**REQUEST**

Approximately 84.16 acres located on the north and south side of Sardis Lane, and east side of Providence Road.

The petition proposes a mixed-use development on parcels that are currently developed with multi-family, commercial, outdoor and indoor recreation.

Levine Properties

RZ2-00

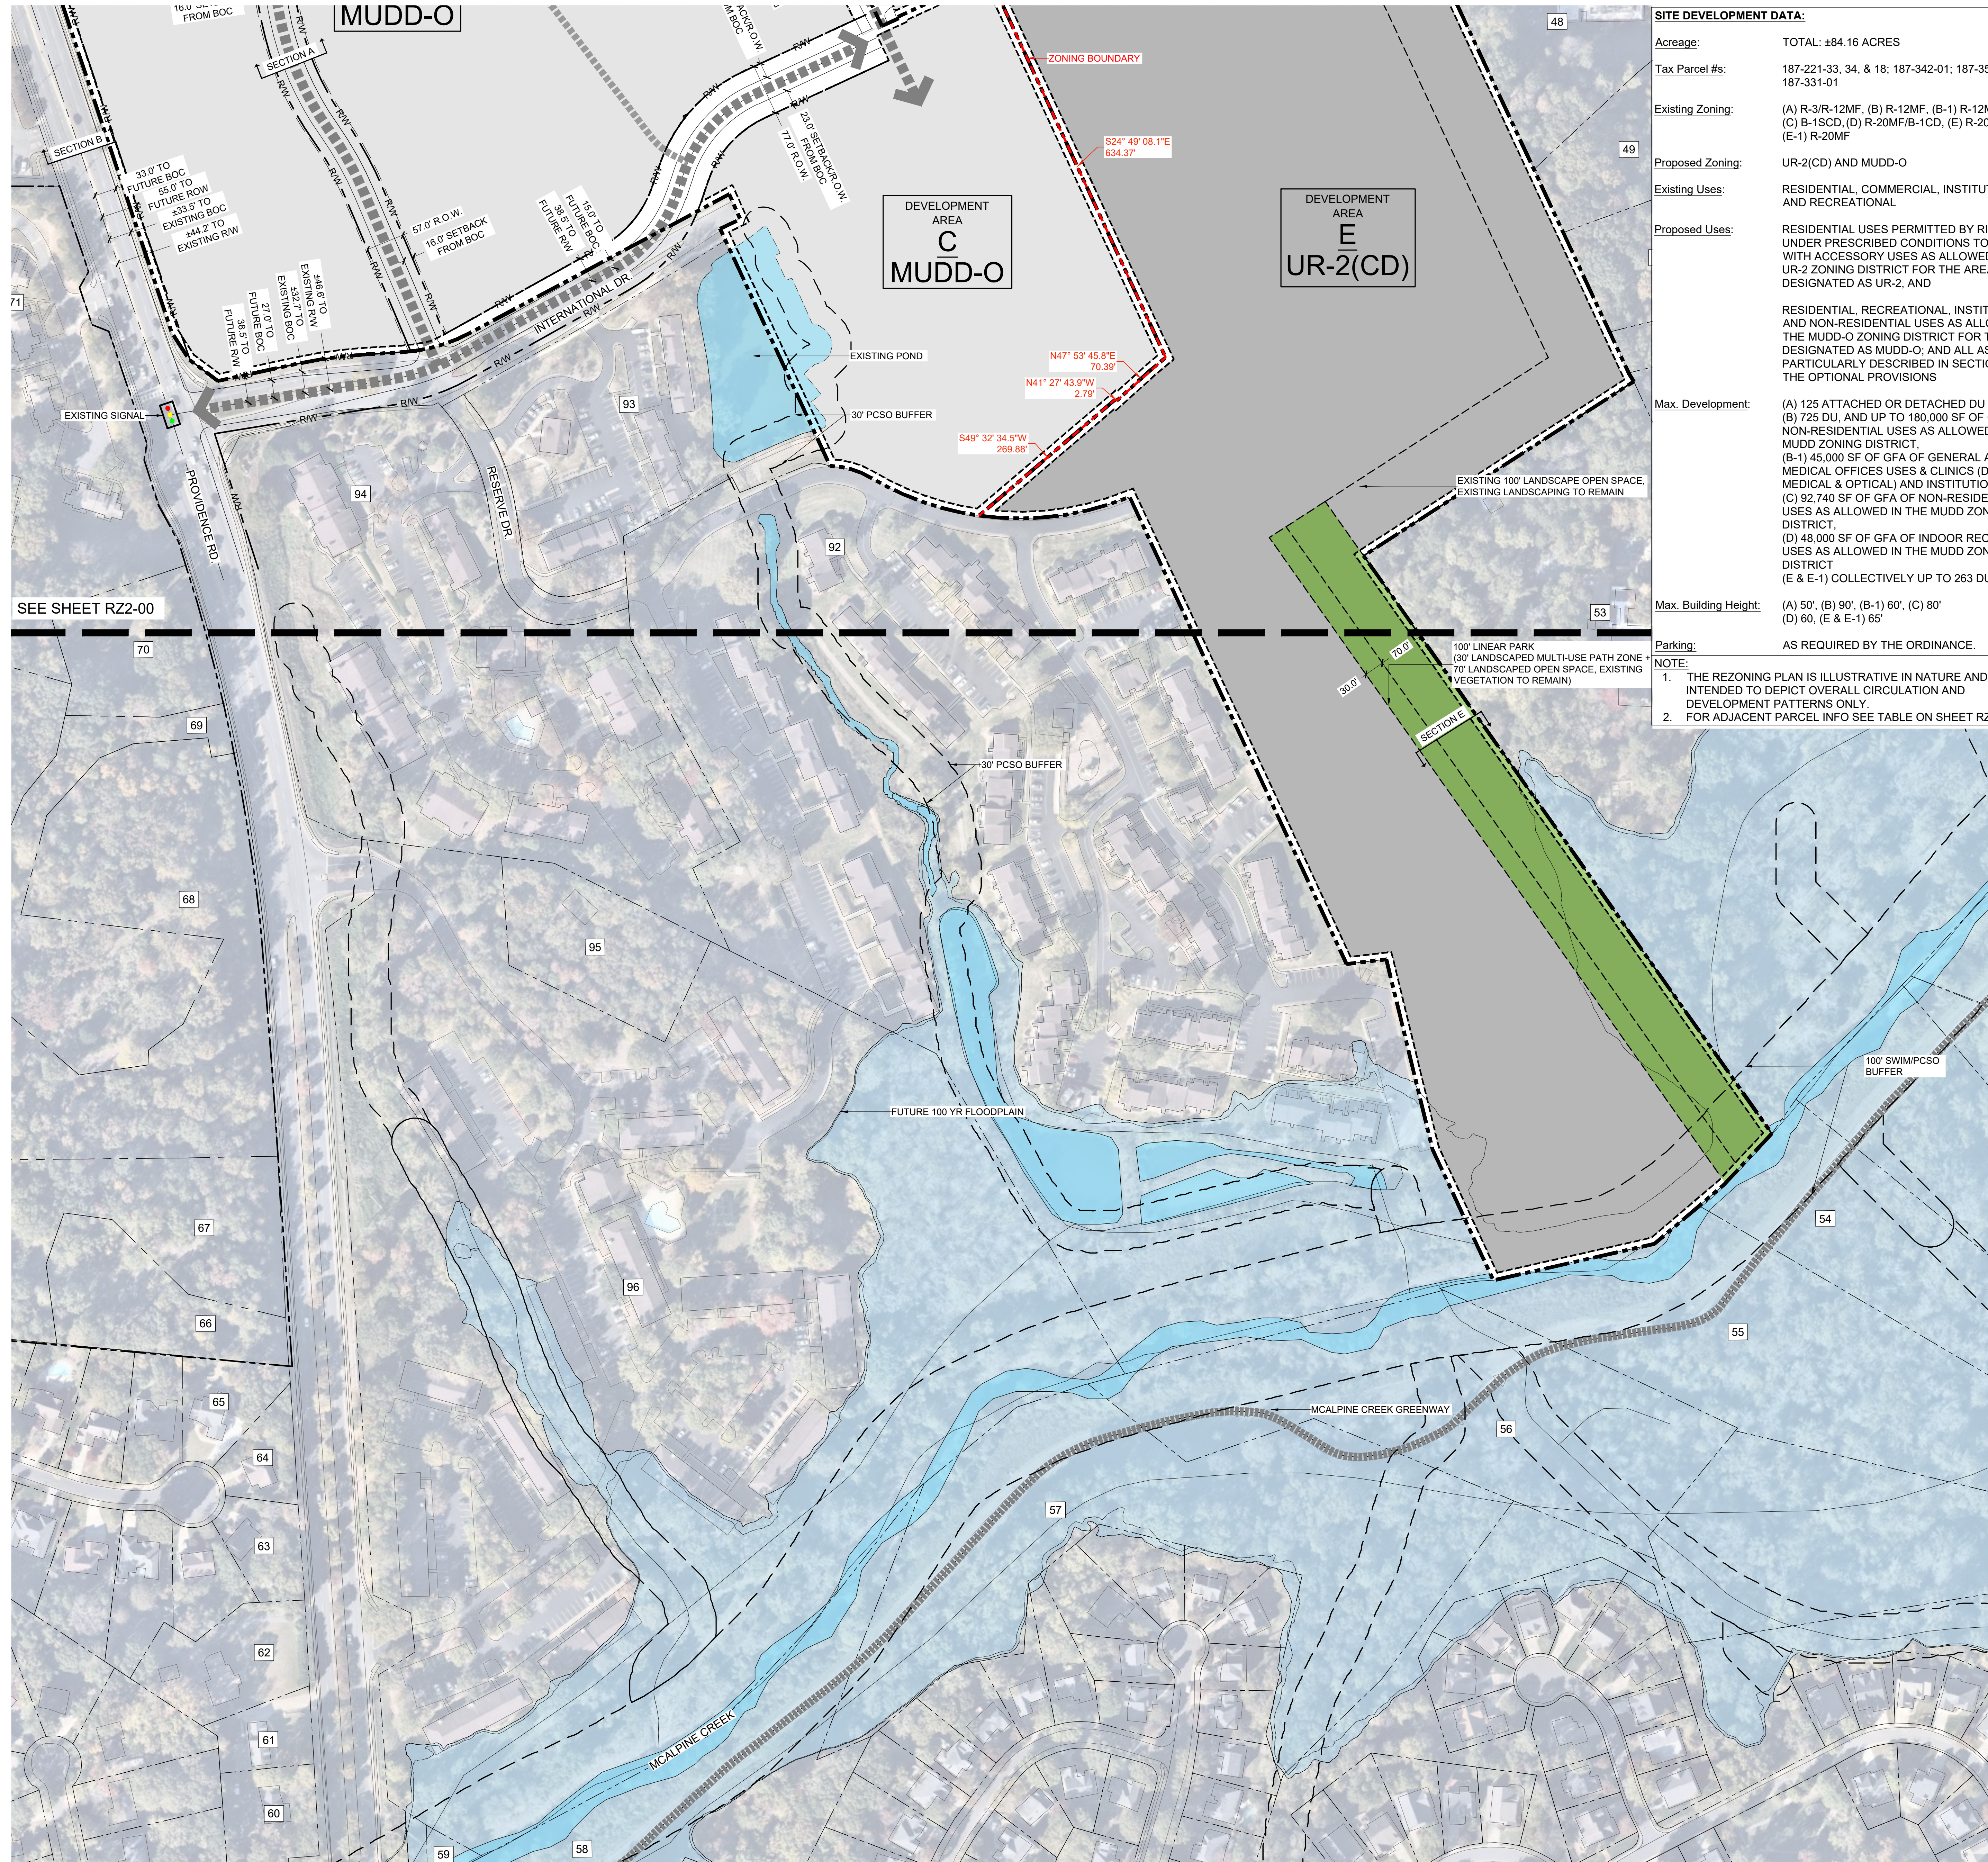
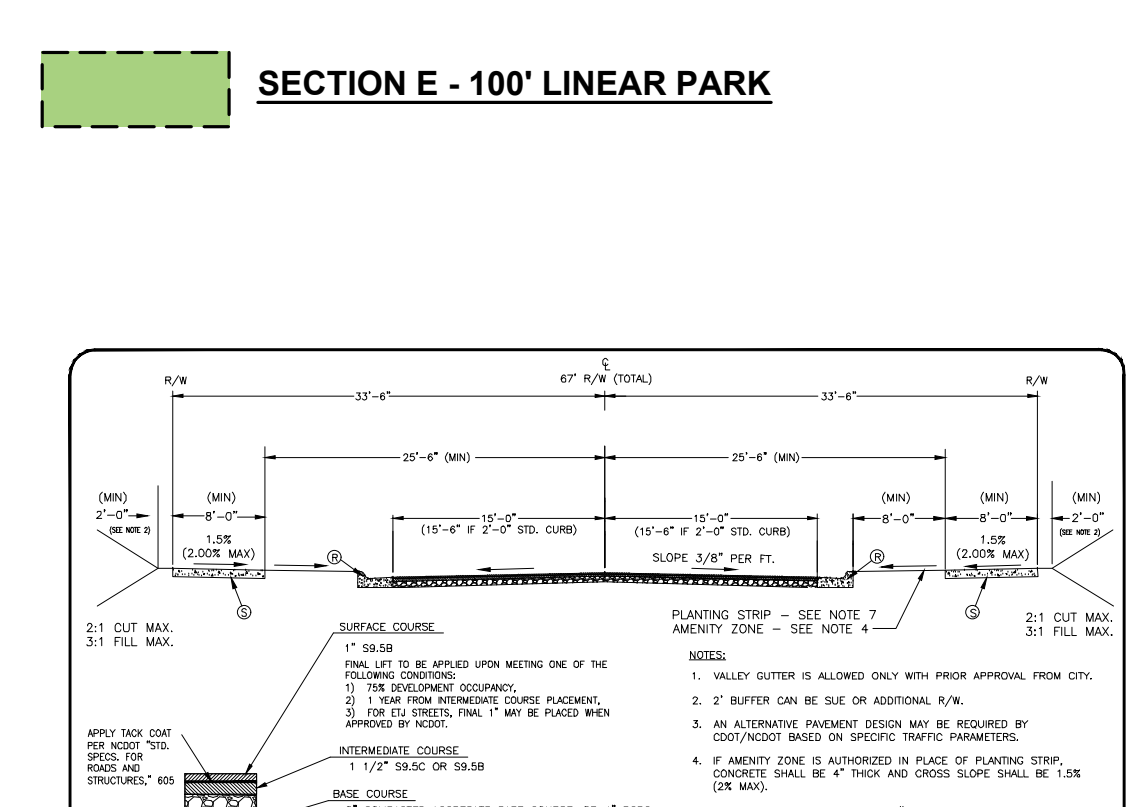
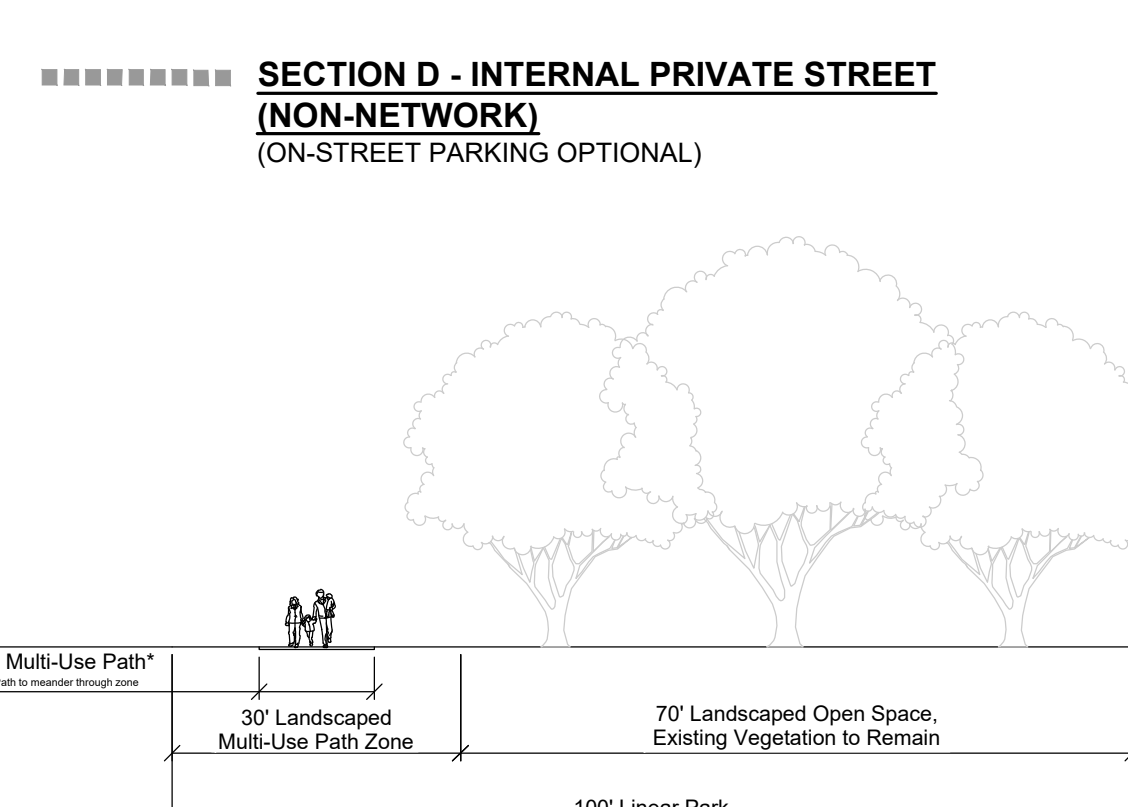
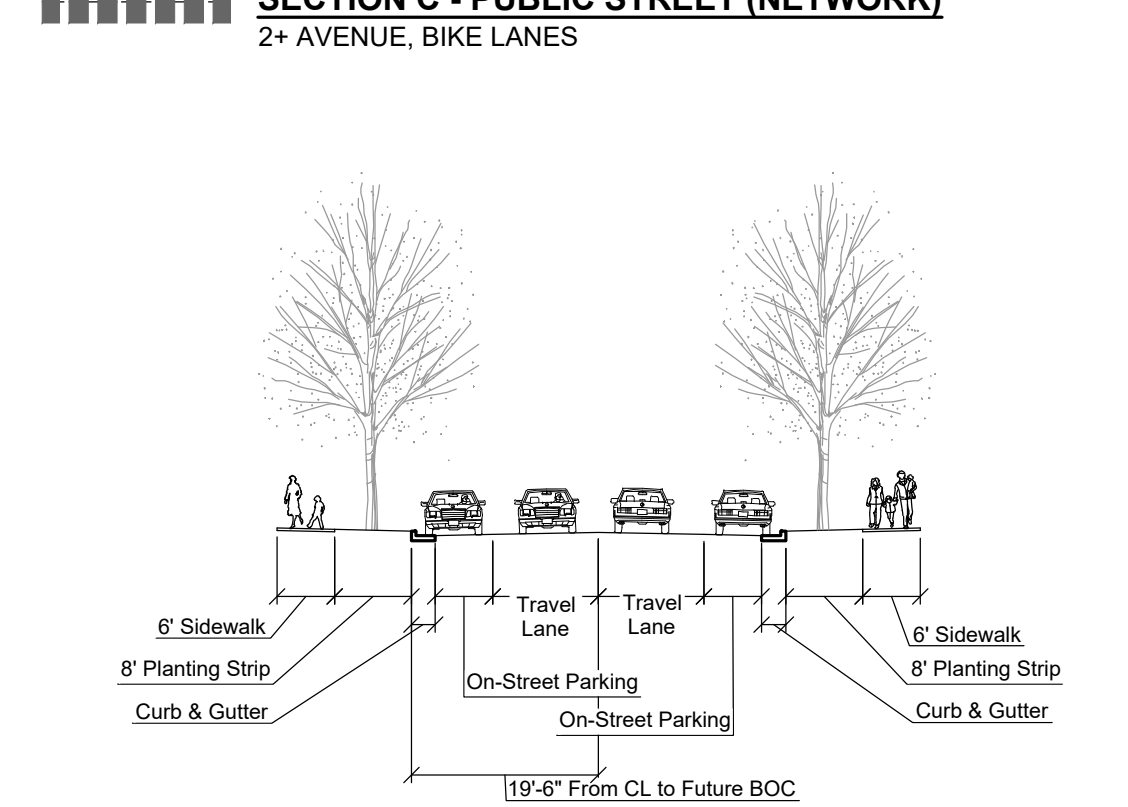
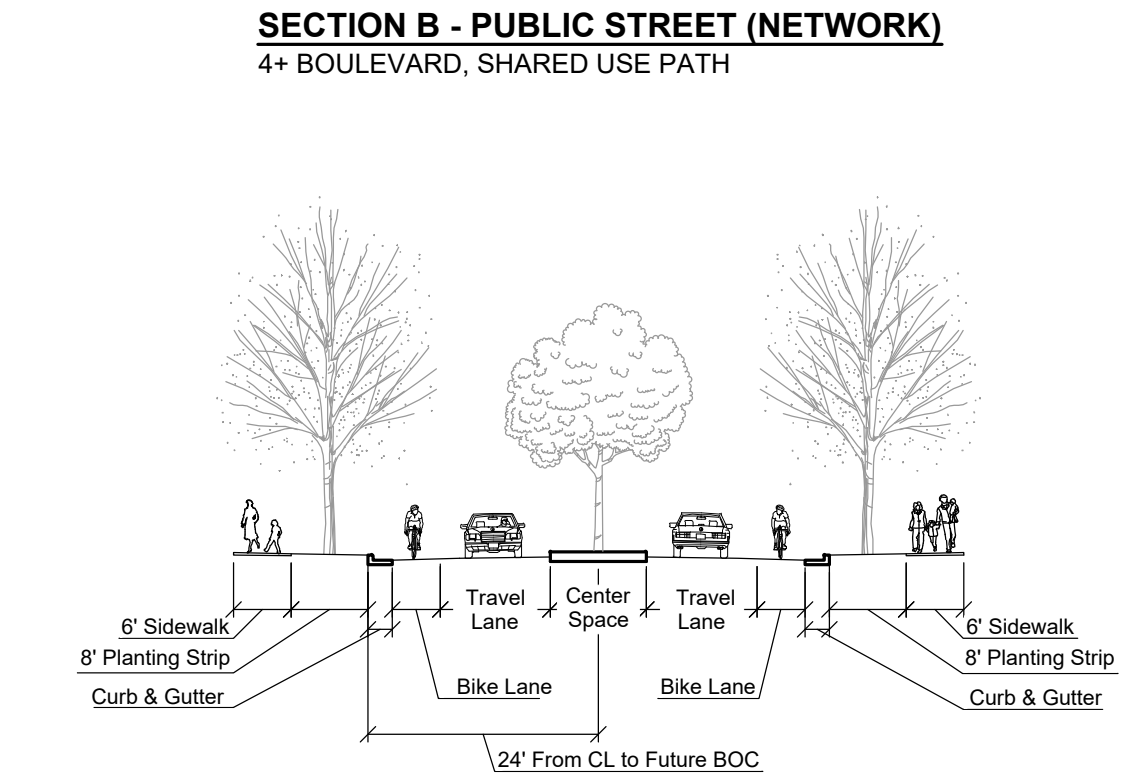
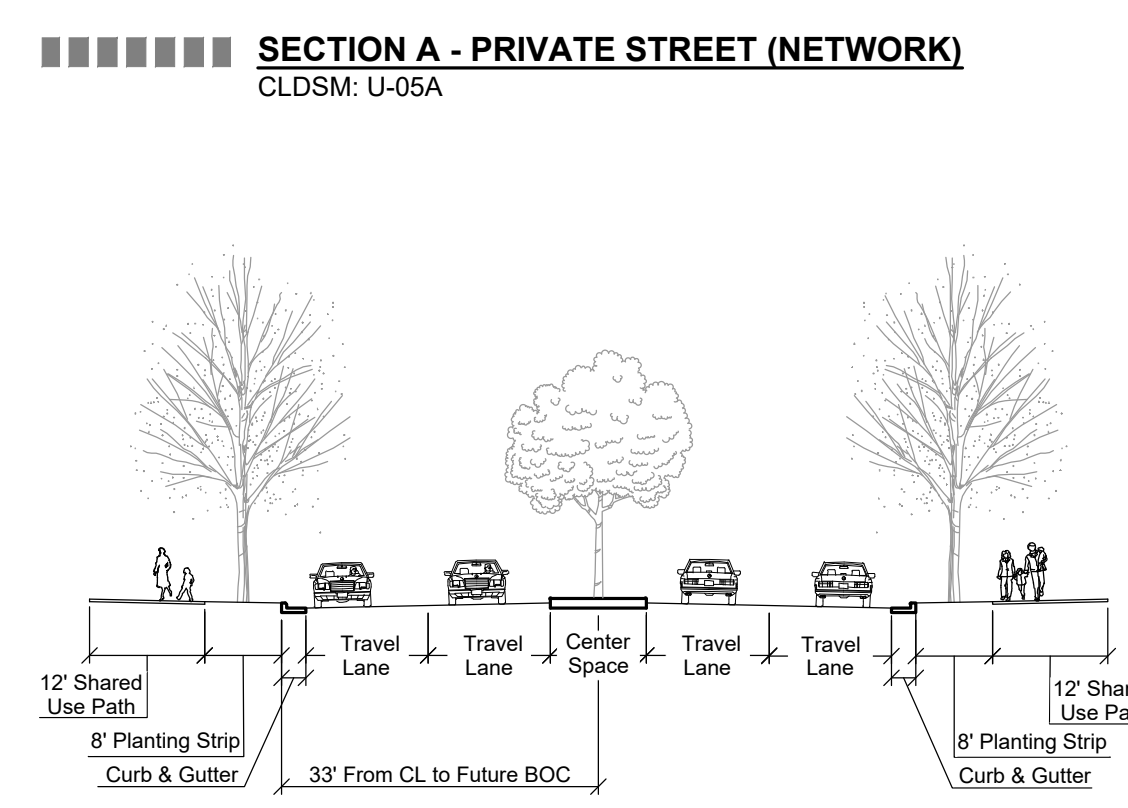
6. Reduce maximum building height for non-residential, mixed-use, and multi-family buildings to 65 feet. Reduce maximum height of single-family attached and detached buildings to 48 feet.

7. Clearly state on the site plan the maximum development potential including maximum number of dwelling units, non-residential square footage, and outdoor recreational facilities. Including all transferable rights between Development Areas and conversion rights.

8. Specify all existing development on site including number of dwelling units, non-residential square footage, and outdoor recreational facilities.
9. Specify one development option for Development Area A.

10. Specify one development option for Development Area B.
11. If multiple development options for Development Areas A and B are to remain, provide clear guidance on what triggers one of the two options to move forward.
